Our ref: DOC22/342243

Your ref: SSD 24452965

### **Subject: EHG comments on Environmental Impact Statement - Eels Centre of Excellence (CoE) and Community Sports Hub (SSD-24452965) (The Hills Shire)**

Figure 23. An overview of the proposed development

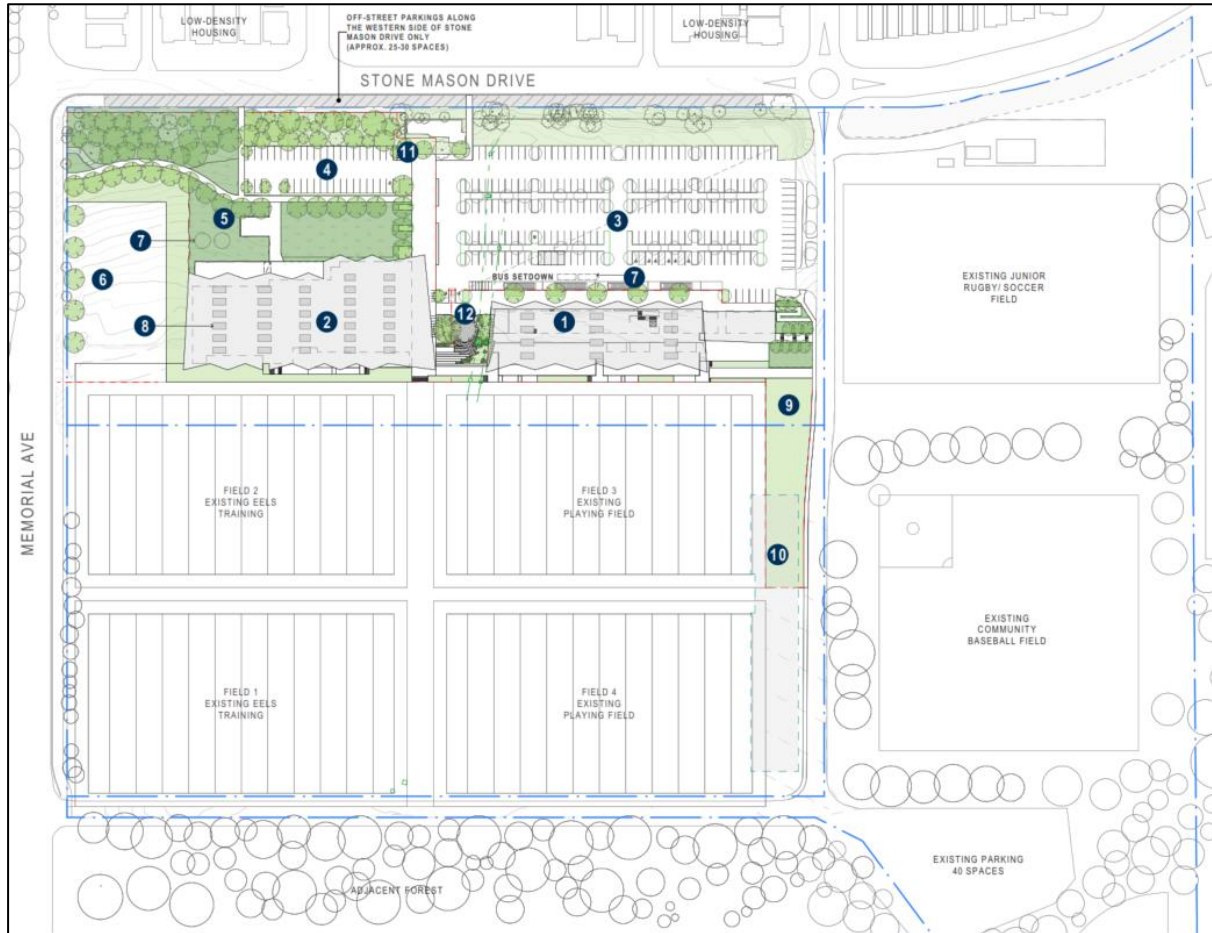
- Opportunities for increased canopy cover should be explored. For example, opportunities may exist to the north of the proposed CoE in the setback from Memorial Avenue. In addition, the proposed turf area to the north of the new car park could be consolidated into the replanting area to increase canopy cover.

- Additional space for planting existing within and adjacent to the proposed stage 2 footprint. This could include replacing areas of turf adjoining the proposed new carpark with tree planting. Turf areas between the CoE and Memorial Avenue may also represent an opportunity for further planting of canopy trees.
